FPCR Environment and Design Ltd

Land off Barnsley Road Goldthorpe – Ecological Note

- 1.1 This note provides responses to comments provided by Yorkshire Wildlife Trust (YWT), Barnsley Metropolitan Borough Council (BMBC) and RSPB, related to the proposed development of Land off Barnsley Road, Goldthorpe ('the Site') (National Grid Reference SE 4414 0356).

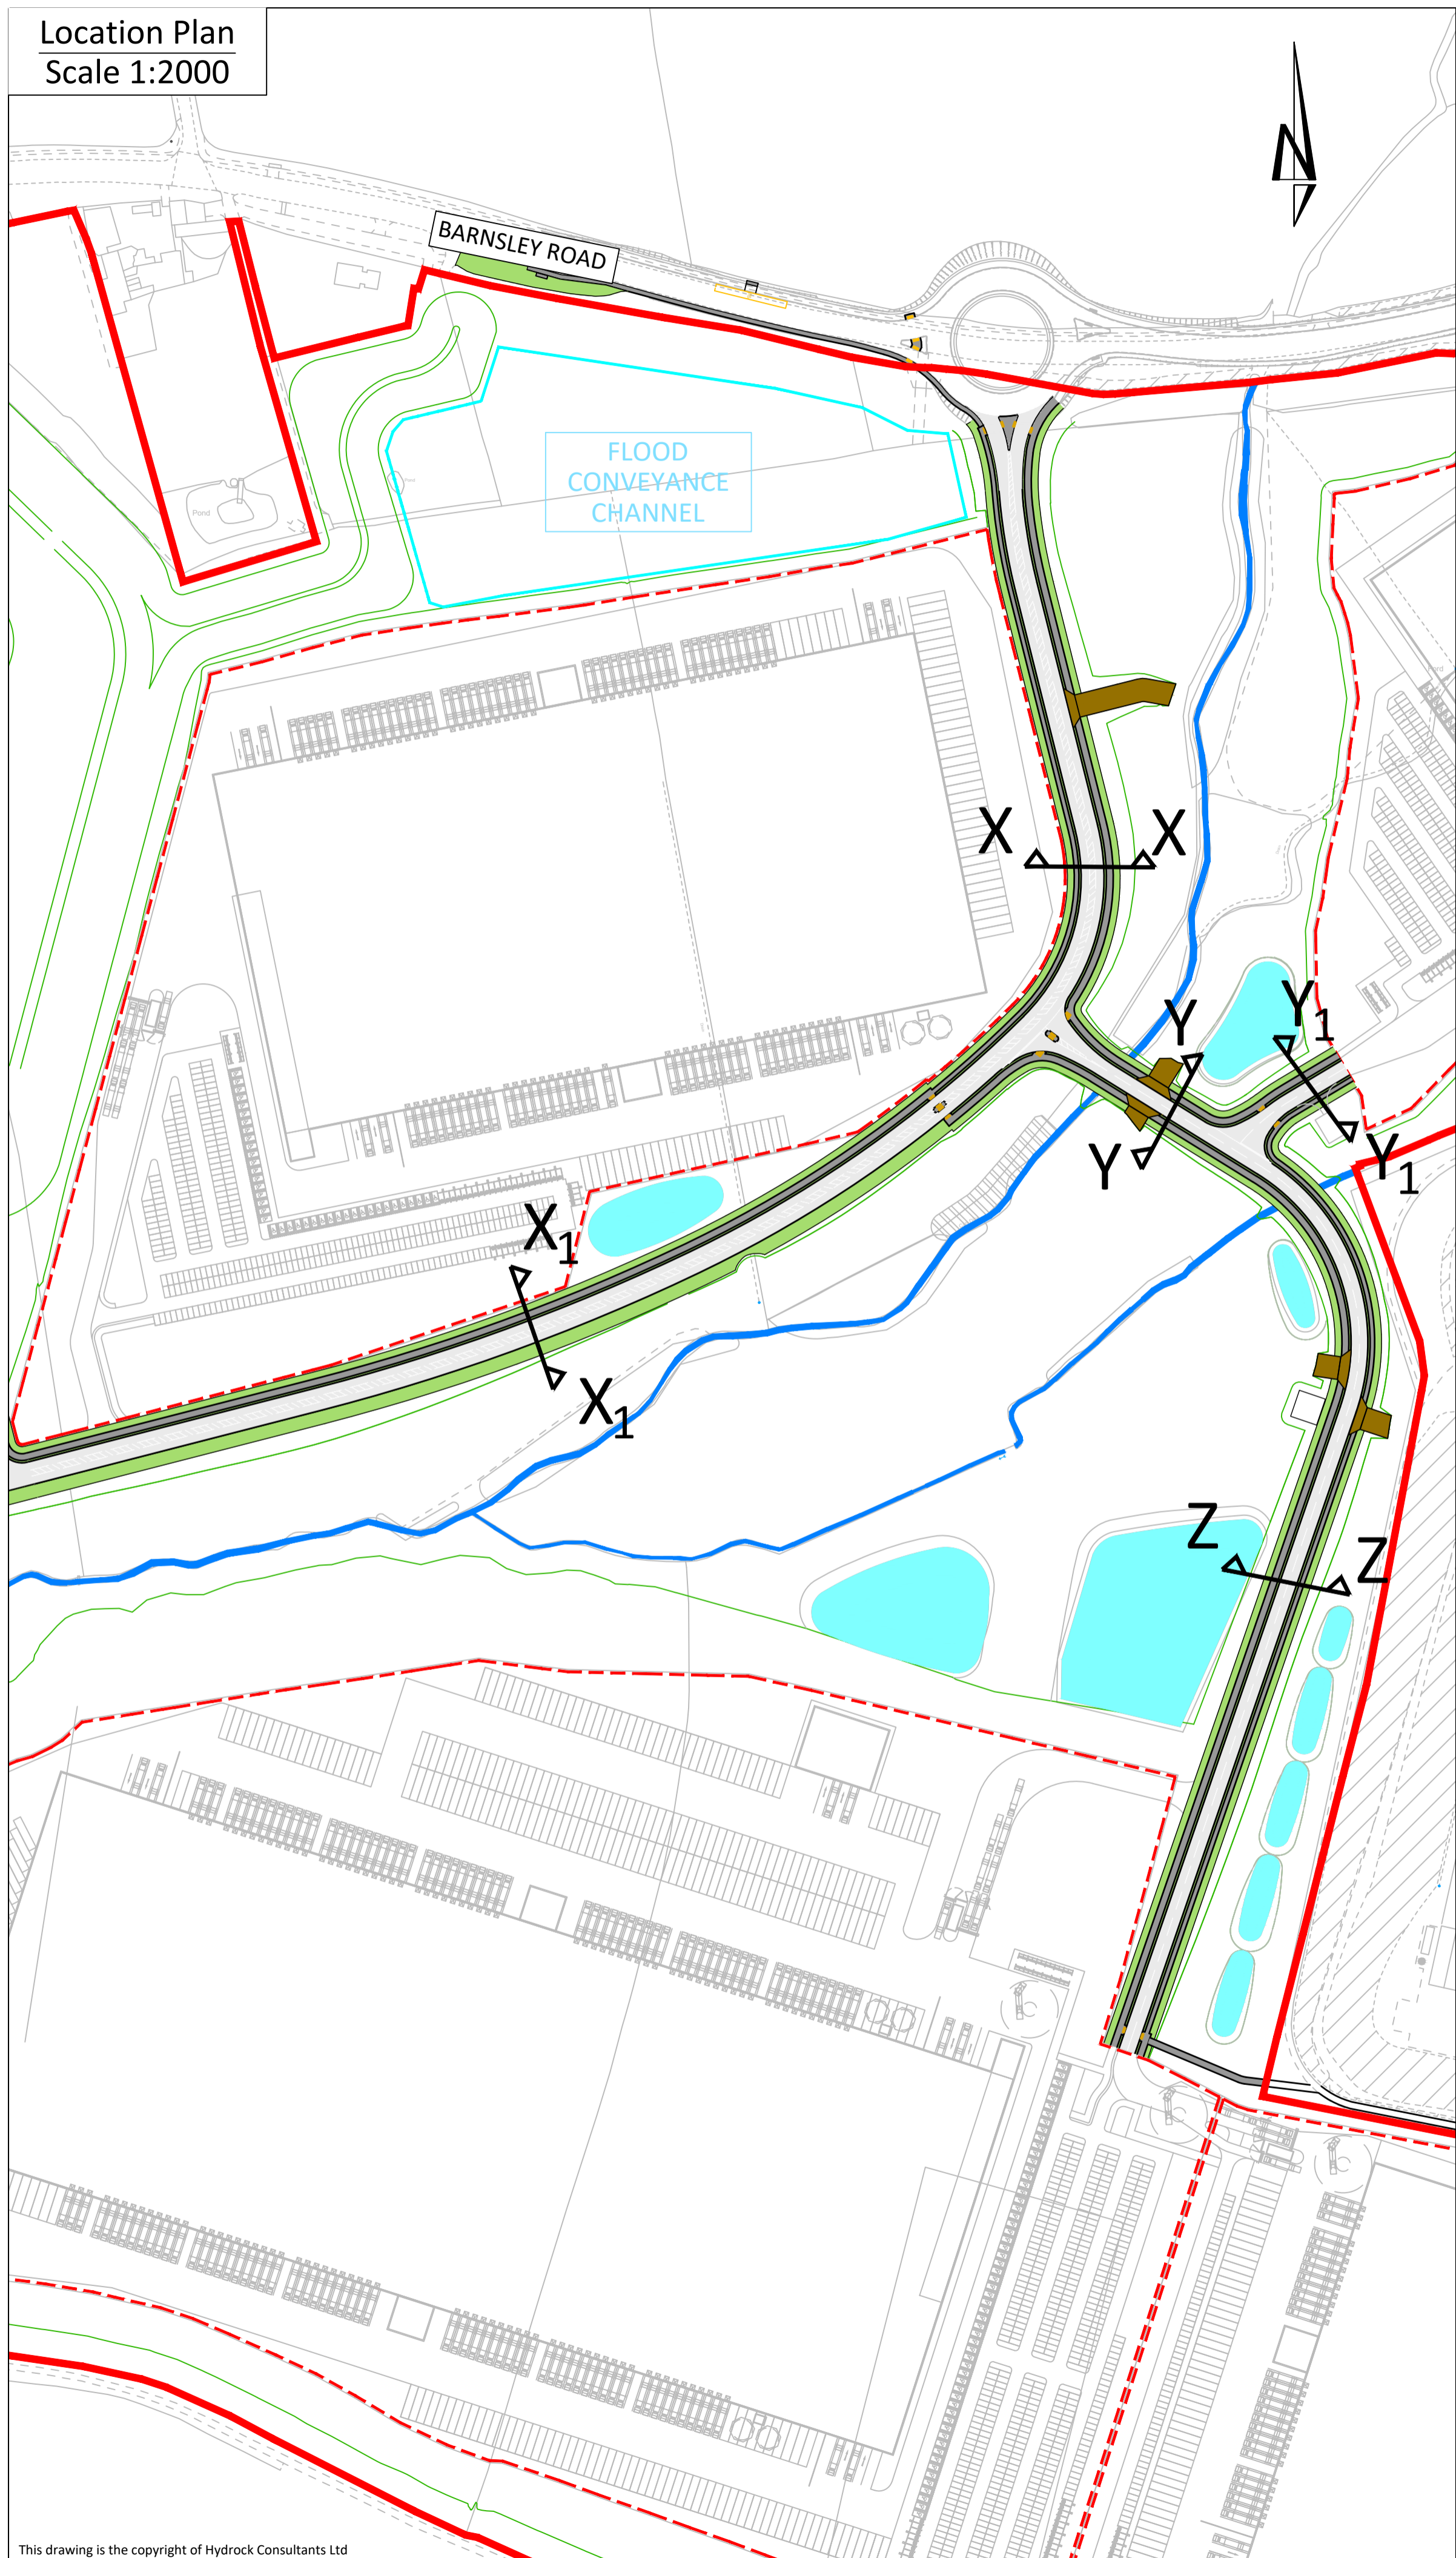
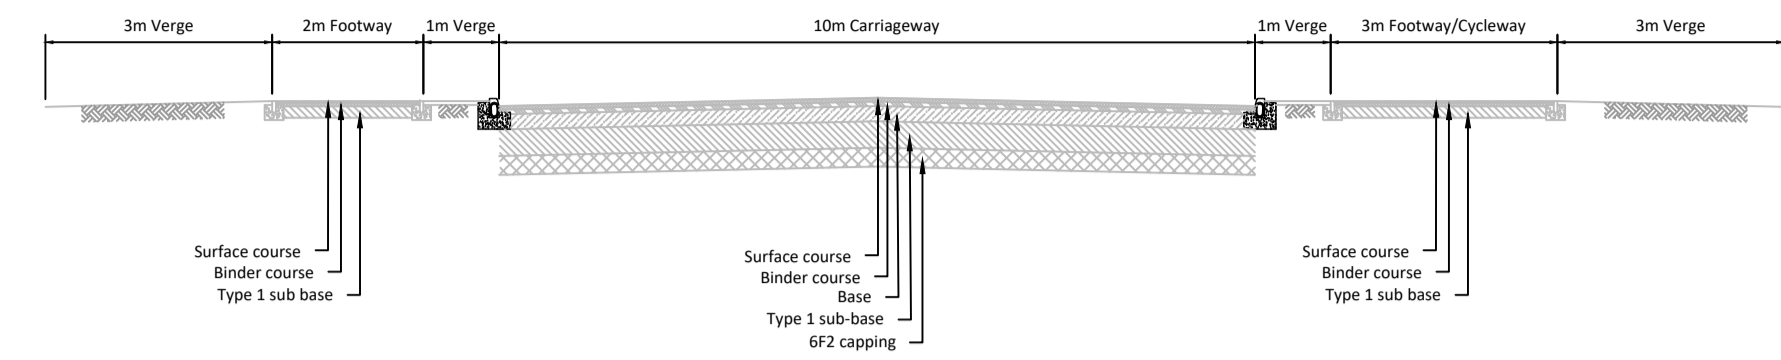
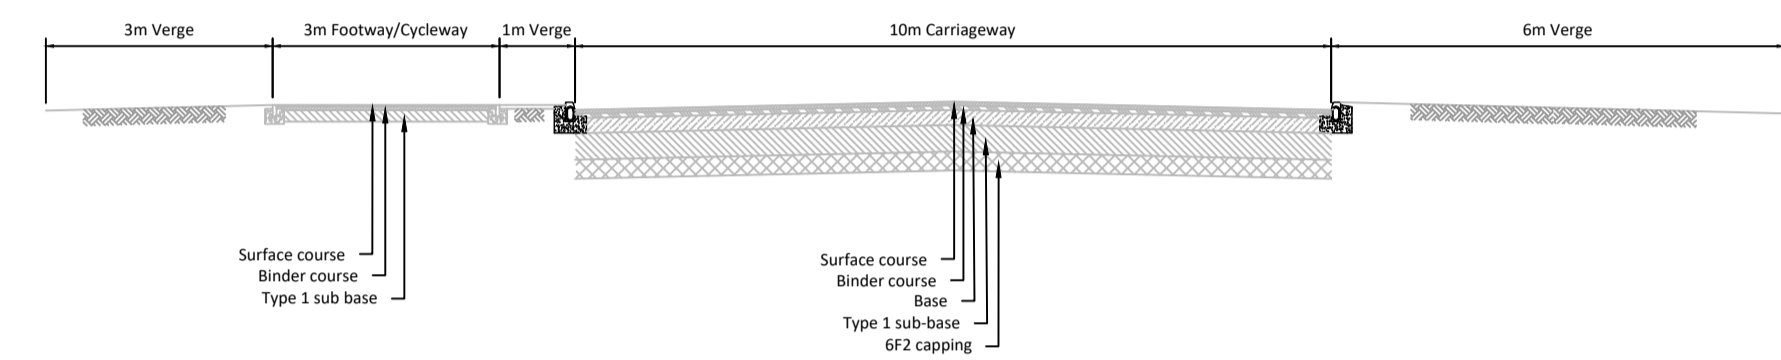
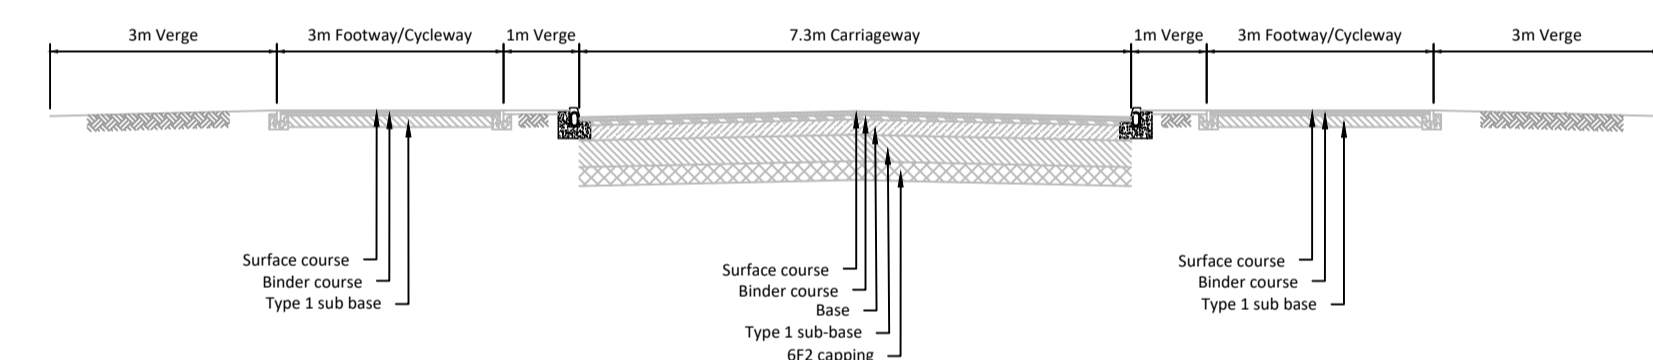
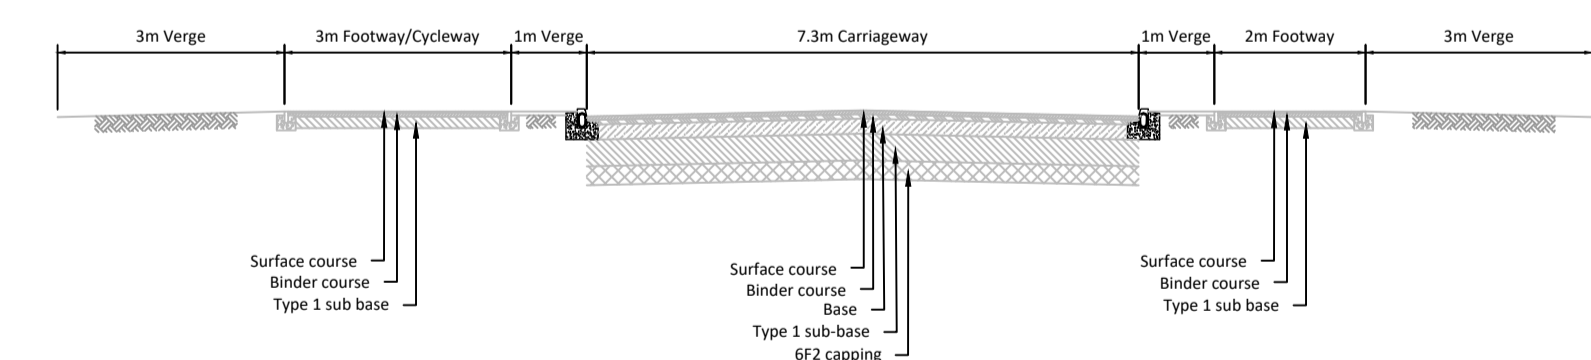
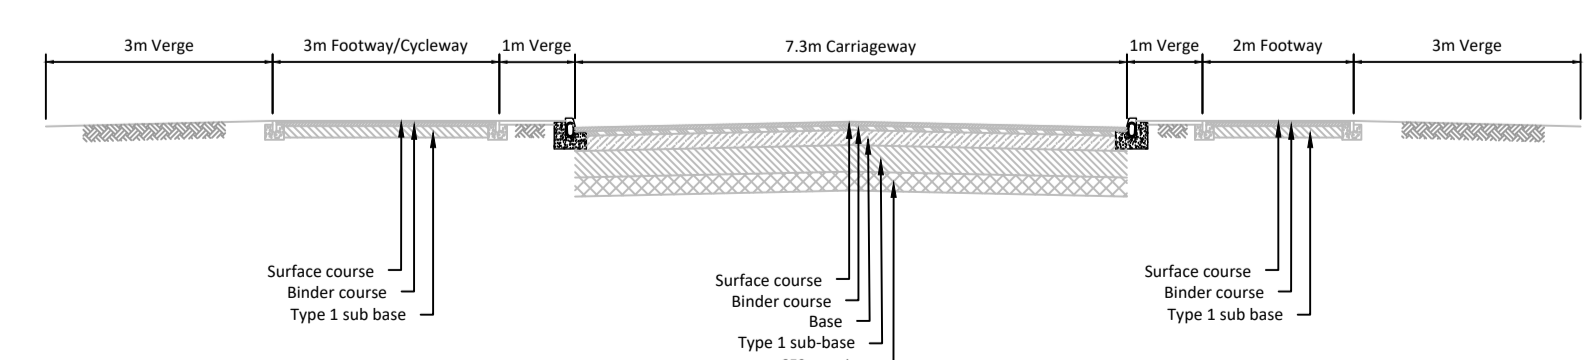
Stakeholder	Comment	Response
BMBC	Highlights the potential for culverts to increase flood risk and severance of habitats	<p>Culverts have been designed to minimise impacts as far as possible whilst still accommodating the required development and taking into account the masterplan and allocation requirements.</p> <p>It is unfeasible to amend the location/length of these given the engineering implications.</p> <p>Engineering has accounted for flood risk and flows.</p> <p>Features highlighted by BMBC will be looked to be accommodated with as many features as possible.</p> <p>Ledges and mammal underpasses will be provided and shown in updated designs.</p> <p>Culverts will be of sufficient size to allow for a natural bed to be provided/develop within the culvert.</p> <p>If required baffles/other features to slow flows and provide shelter and natural bed development will be incorporated.</p>

BMBC	Culvert design and BNG culvert lengths do not match.	The BNG assessment was made using the Site masterplan document. FPCR are reviewing the calculation of the rivers/watercourses section of the BNG metric using the maximum design lengths provided for the culverts.
BMBC	BNG report states urban trees to be retained but not shown in metric	BNG report is incorrect and will be amended. See habitats section above.
BMBC	Delay in habitat creation – phased development	Application is hybrid. The built development plots will be phased but habitat creation will be front loaded. No delay to habitat creation is expected.
BMBC	Phases to produce updated metric Phases to produce HMMPs	Discuss if required given that all habitat creation will be done prior to phases. Discuss if required given that all habitat creation will be done prior to phases. A sitewide LEMP/BEMP will be produced which will cover the 30-year management of habitats across the Site
